Historic England

**APPLICATION BY LUTONRISING FOR AN ORDER GRANTING DEVELOPMENT
CONSENT FOR THE PROPOSED EXPANSION OF THE EXISTING AIRPORT**

APPLICATION REF: TR020001

**REPRESENTATIONS OF THE HISTORIC BUILDINGS AND MONUMENTS
COMMISSION FOR ENGLAND (HISTORIC ENGLAND)**

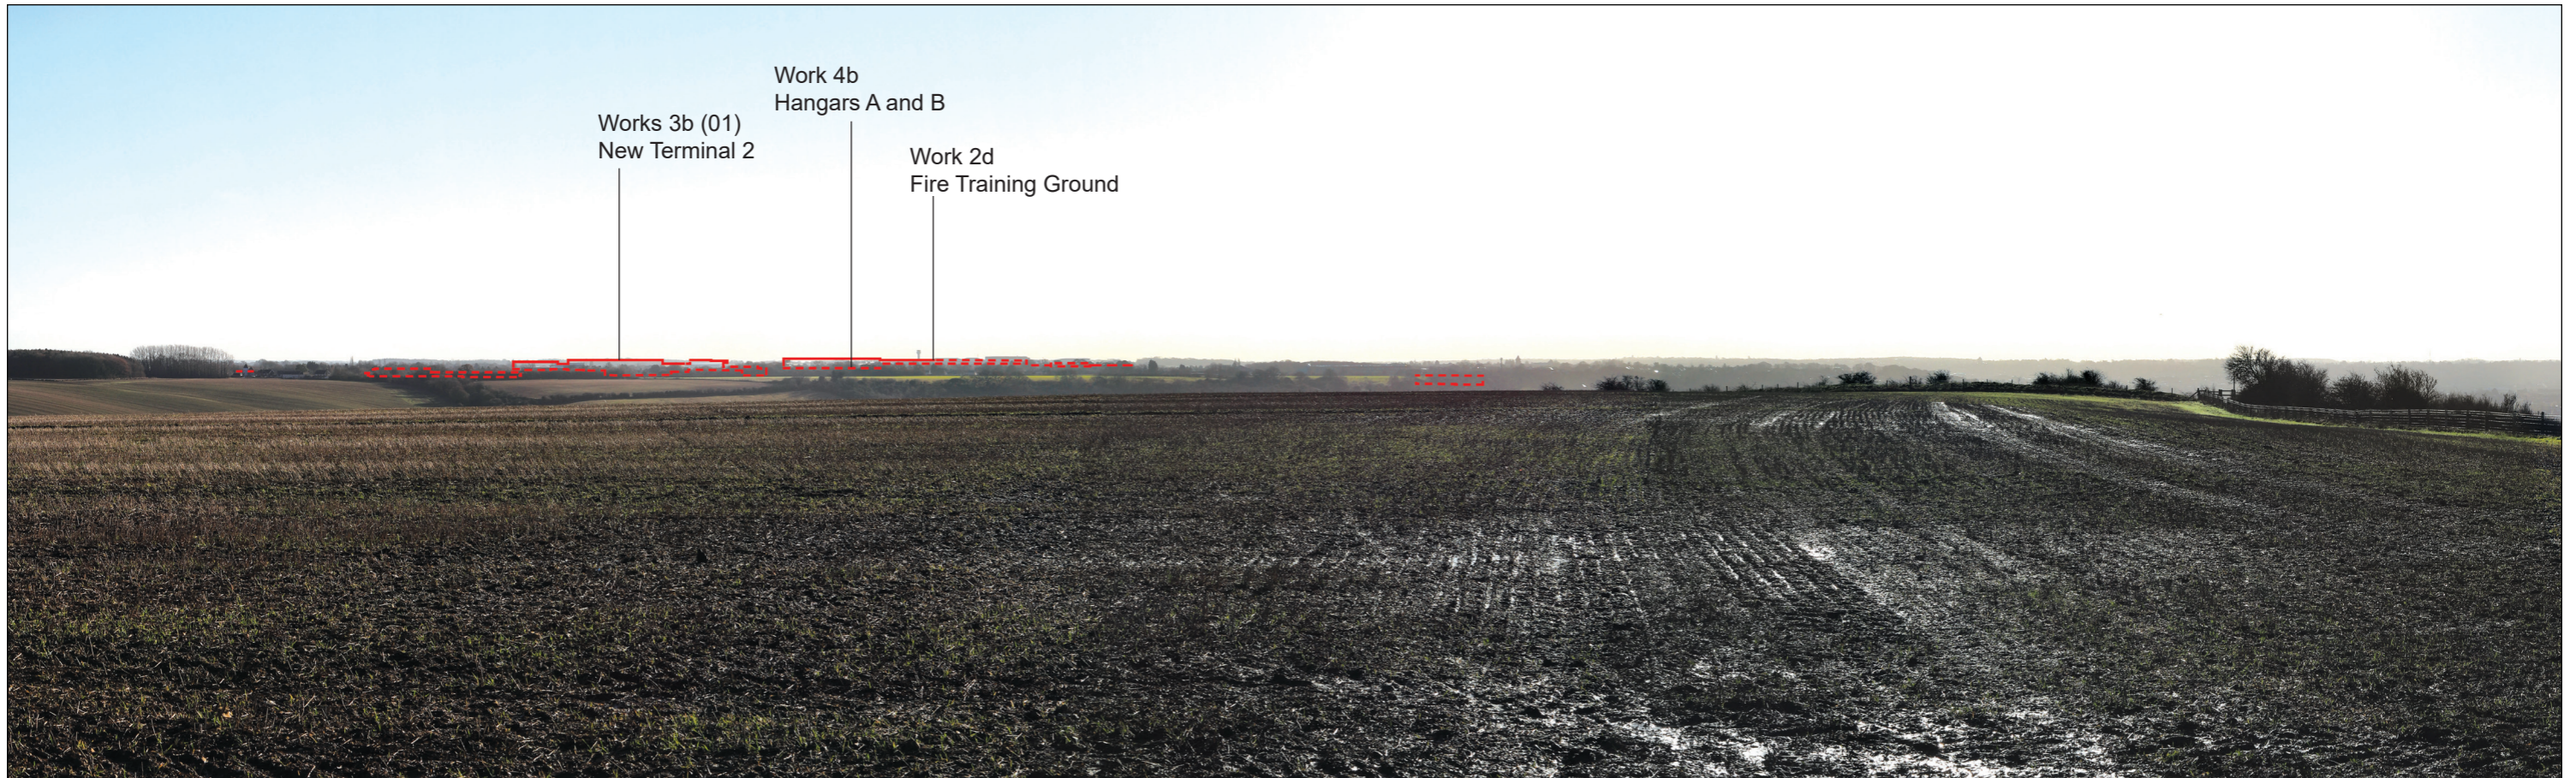
- 2.12 The proposed development would introduce additional bulky and tall structures within the wider setting of both Someries Castle and Luton Hoo estate which are likely to be apparent in some long views from parts of these assets, as demonstrated in the visualisation provided (Viewpoints 18, 19 and 25 (vol 5.02 Appendix 14.7)).

- 2.13 Viewpoint 18 illustrates how the existing horizon has a thick tree-belt and no discernible built form or development other than the 'fin' of the dart bridge. The subsequent images show the visual effect of the proposed building and suggest that it would be somewhat prominent in this view above the skyline. Whilst we appreciate that this may not necessarily be considered to be a key or designed view that is intrinsic to the significance and understanding of the heritage assets, we believe that the presence of the new structure would have a somewhat negative effect upon the way this part of the parkland is experienced and enjoyed.

- 2.14 Viewpoint 19 indicates that additional building would effectively infill the existing gap between the existing airport buildings – already prominent in this view by virtue of their brightly coloured cladding, thereby further consolidating the built form to some extent.

- 2.15 Similarly viewpoint 25 suggest that the horizon would be interrupted by new building(s), which would be prominent in easterly views of Someries Castle.

- 2.17 We understand that no mitigation measures are proposed in this regard. Therefore we suggest that the visual effects of the proposed new buildings and structures and the impact that they have in terms of setting might be mitigated to some extent through the choice of materials, colour palette and finishes used on the elevations and roofs.
